CD V_1.pdf Markup Summary

PUDSP-16-01
EGP-18-002

Drainage Report V_1.pdf Markup Summary

GEC Plan V_1.pdf Markup Summary

PROJECT NO. 100.044
 SHEET NUMBER C8.6
 TOTAL SHEETS: 19

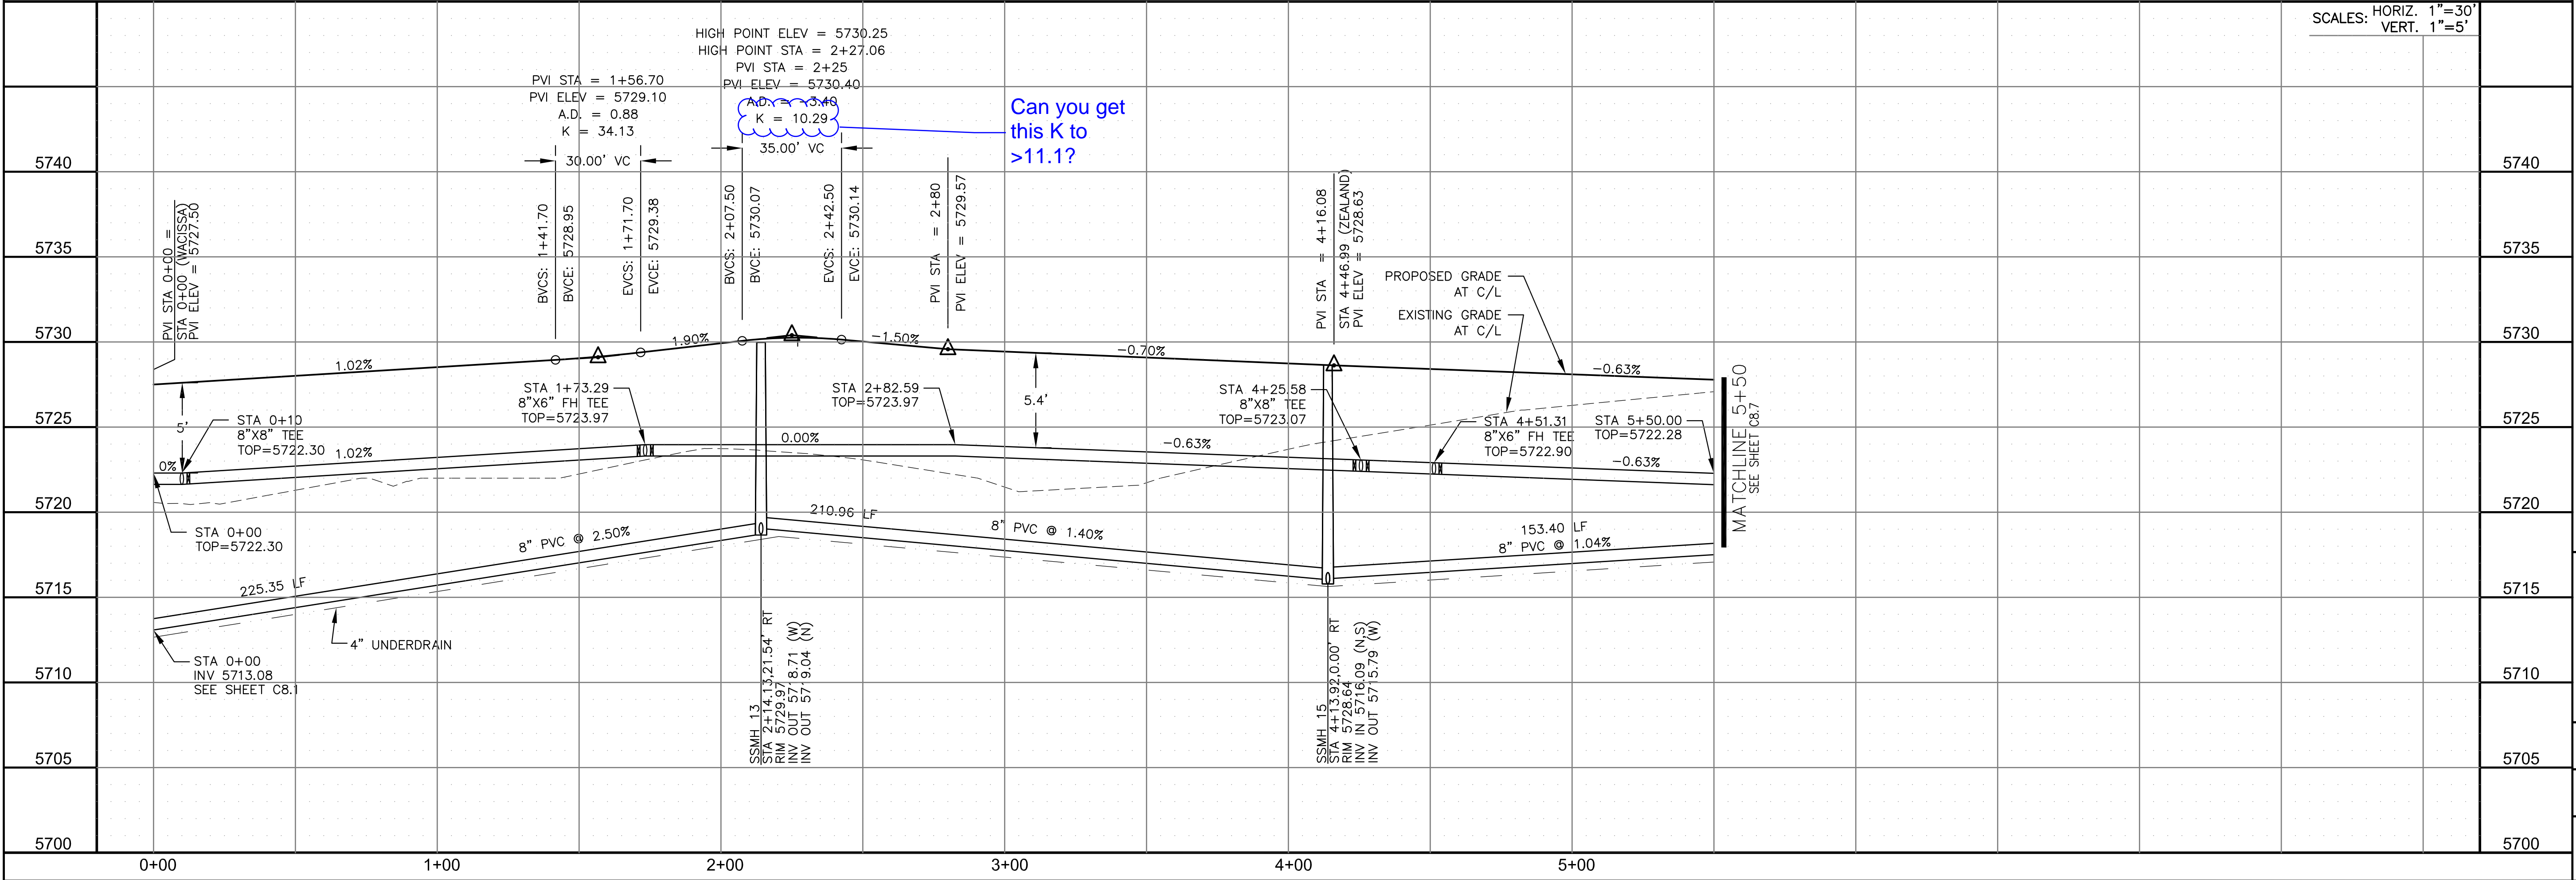
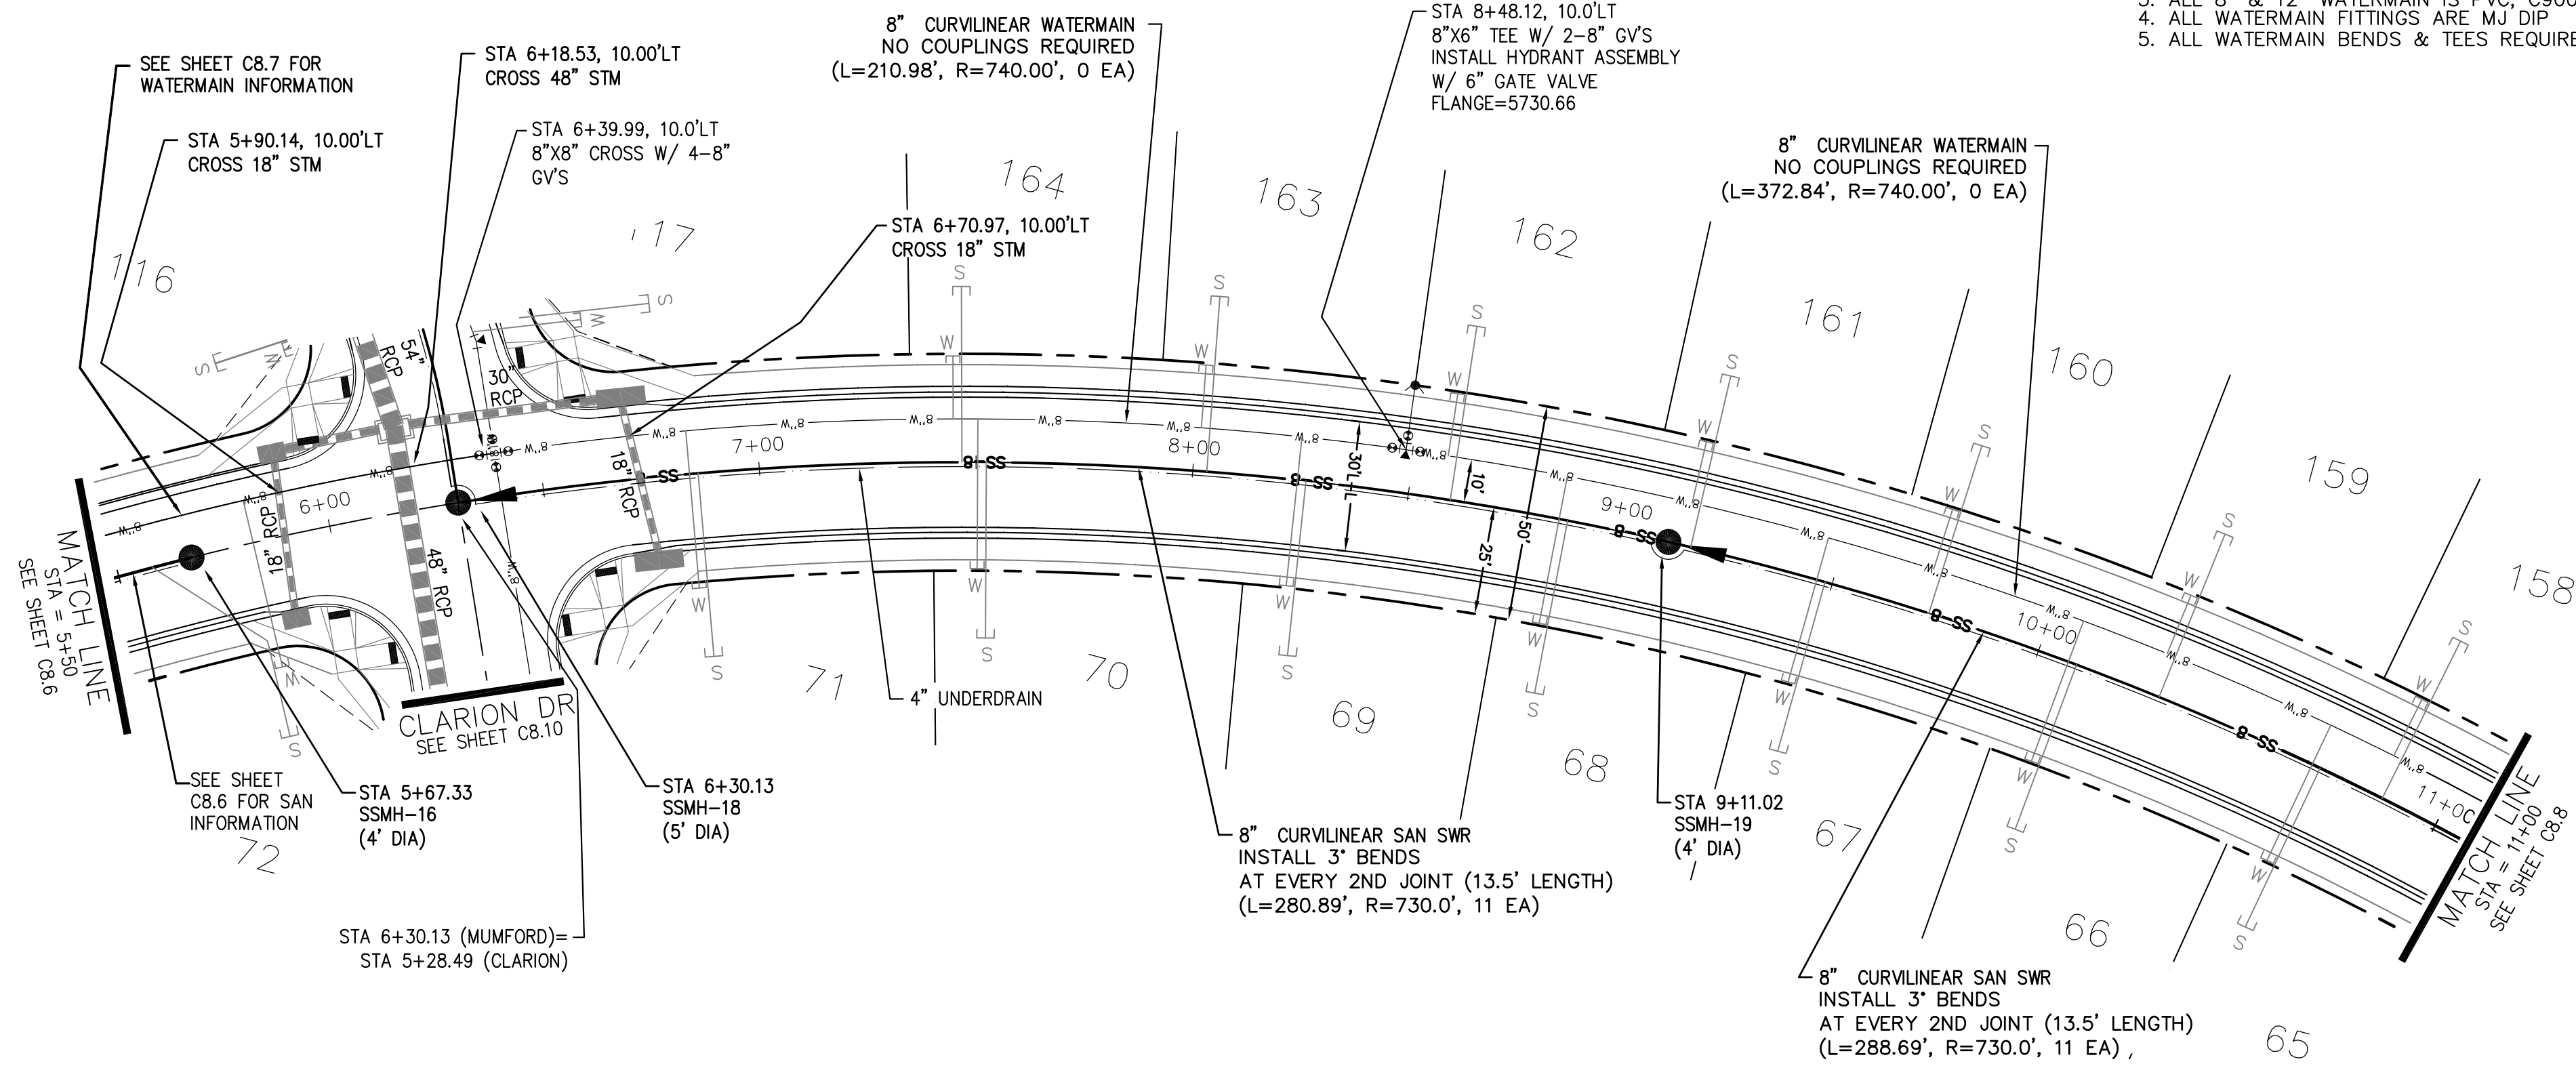
Can you get this K to >11.1?

**LORSON RANCH EAST FILING NO. 2
 FINAL GRADING AND E.C. PLAN
 EAST AREA - OFFSITE GRADING**

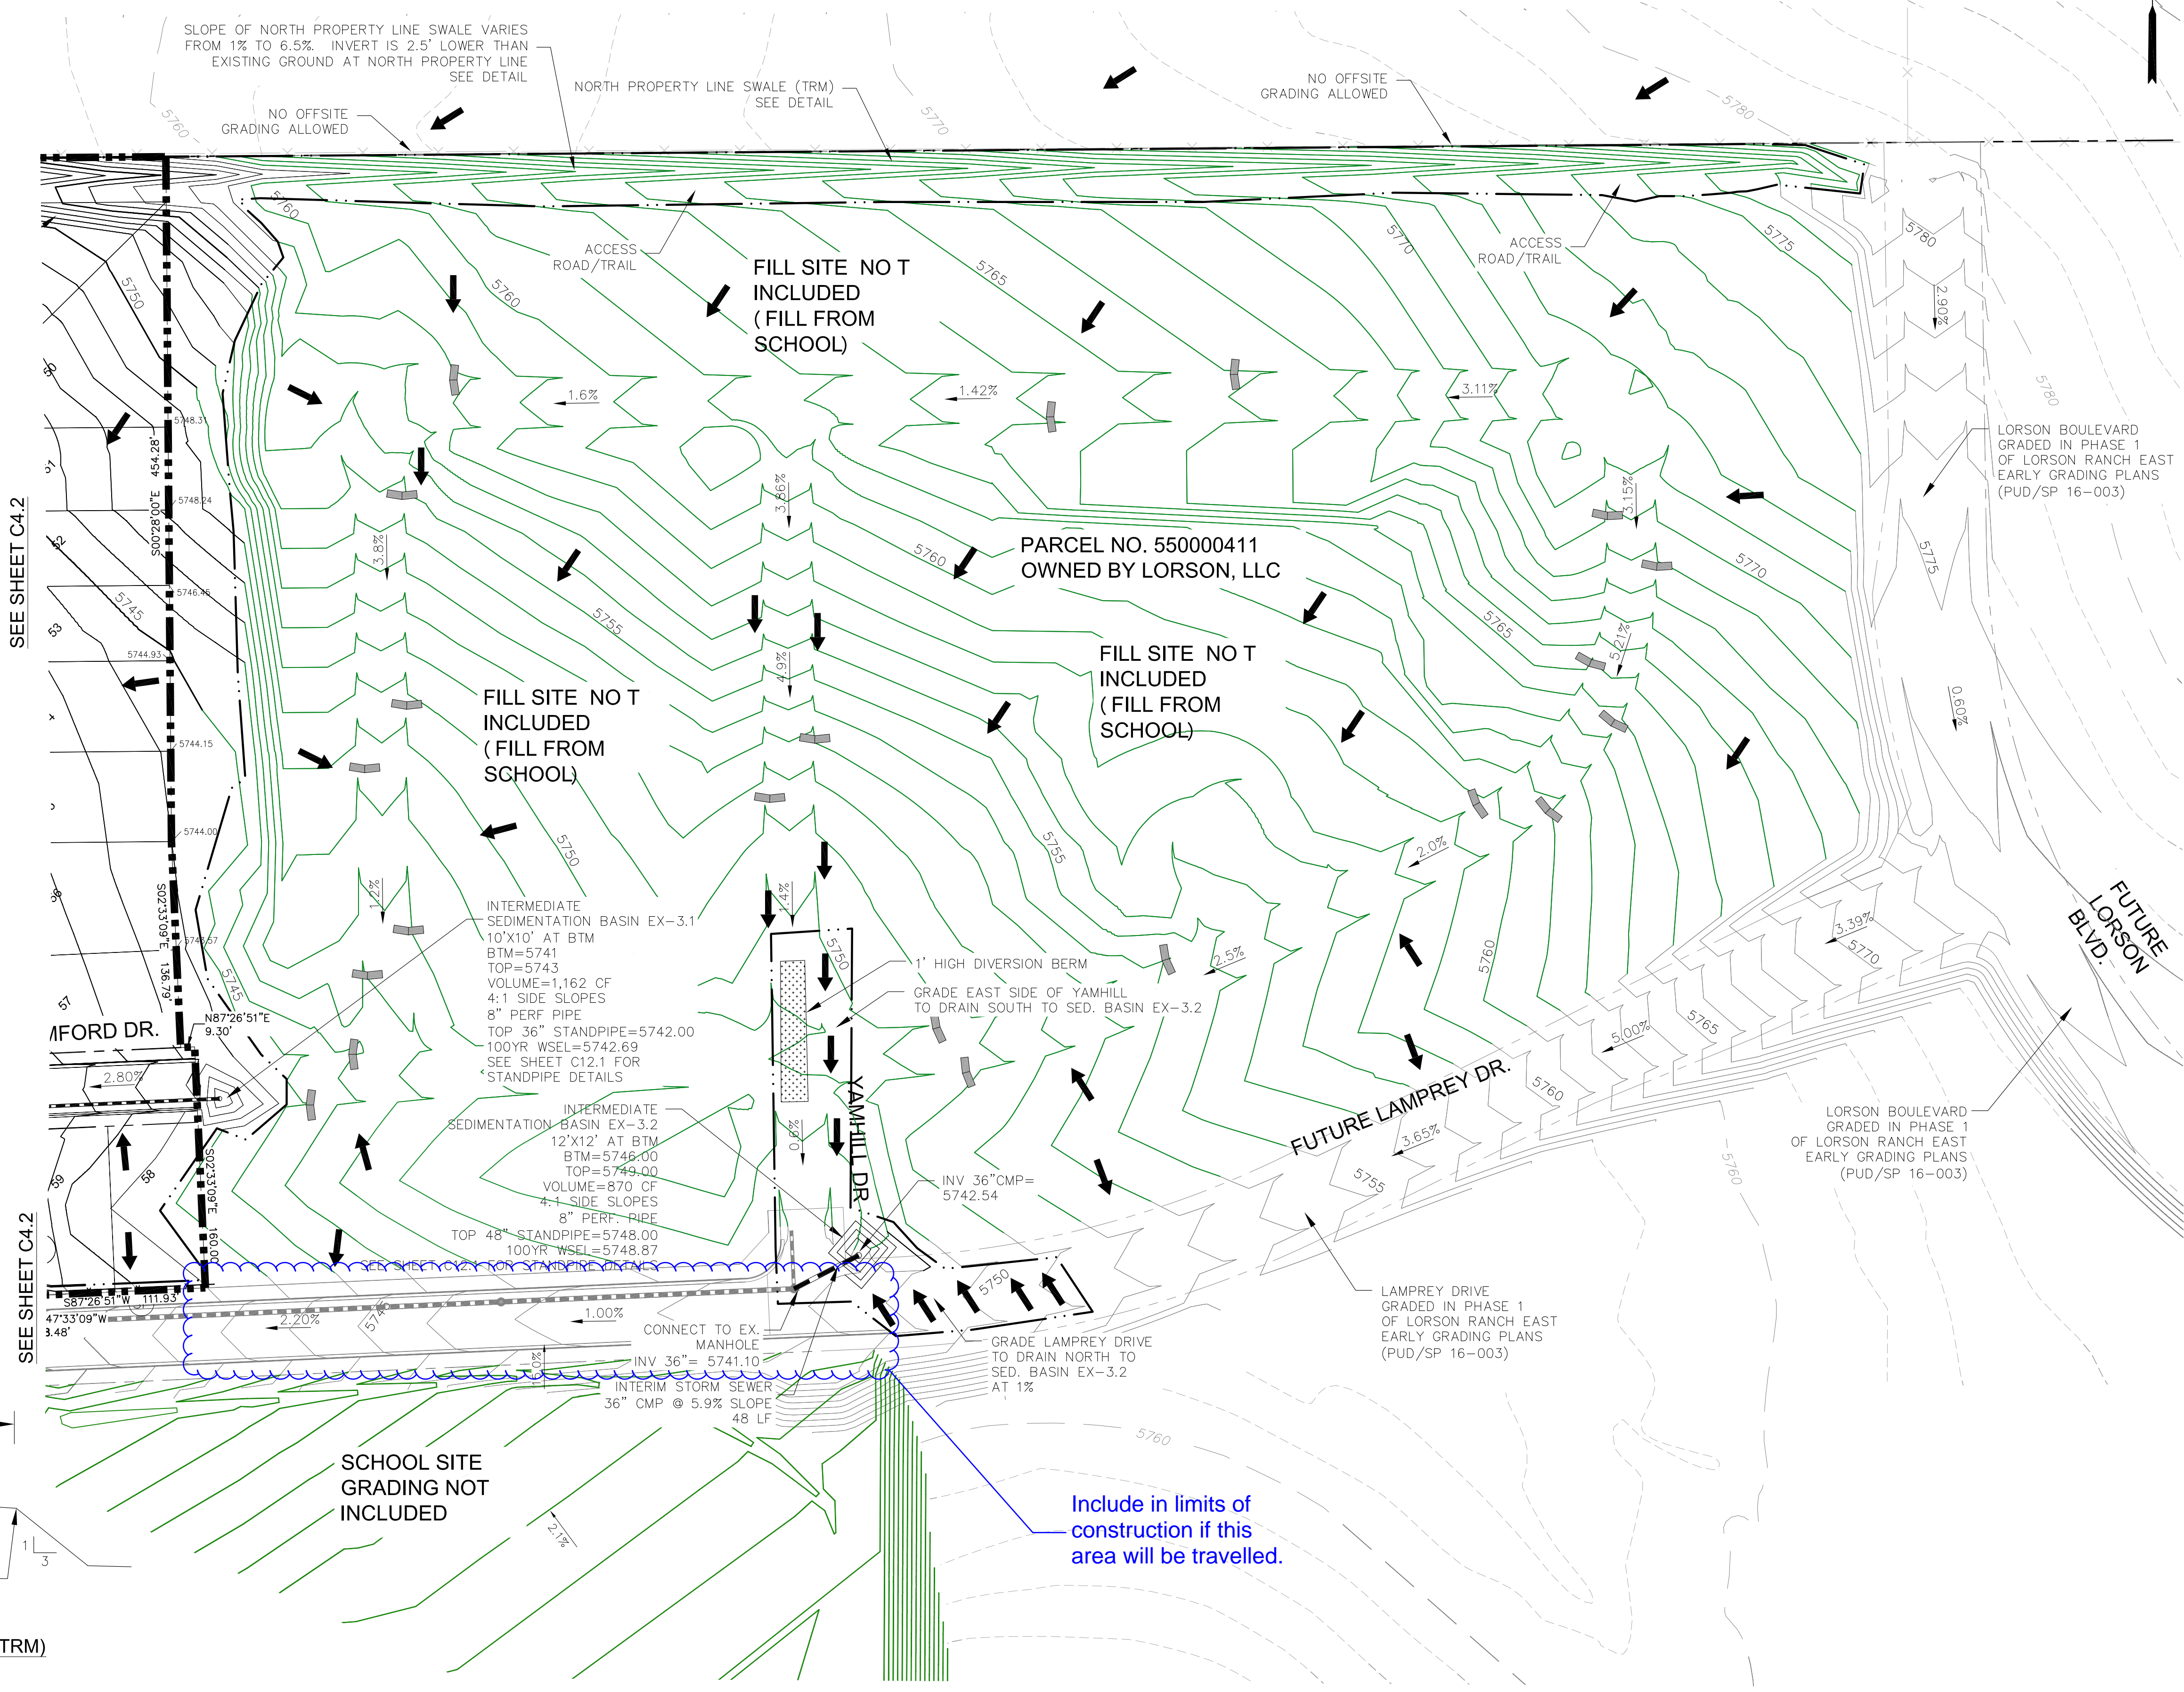
Provide a clearly defined berm or swale to keep sub-basin flows separate (contours show a road that doesn't exist).

Label TRM

Include the entire flow path for flows from here.

Please call out who owns this parcel and all adjacent parcels. please clarify if you are installing the checks shown on this parcel. if owned by someone other than this developer, permission to grade on others property will be required.

this pipe should be included in the limits of disturbance. Also, how will you access this area. This access should be shown within the limits of "construction site boundaries"

Ditch checks or other BMPs are required

Label each slope through the channel and provide appropriate protection.

6.5%?
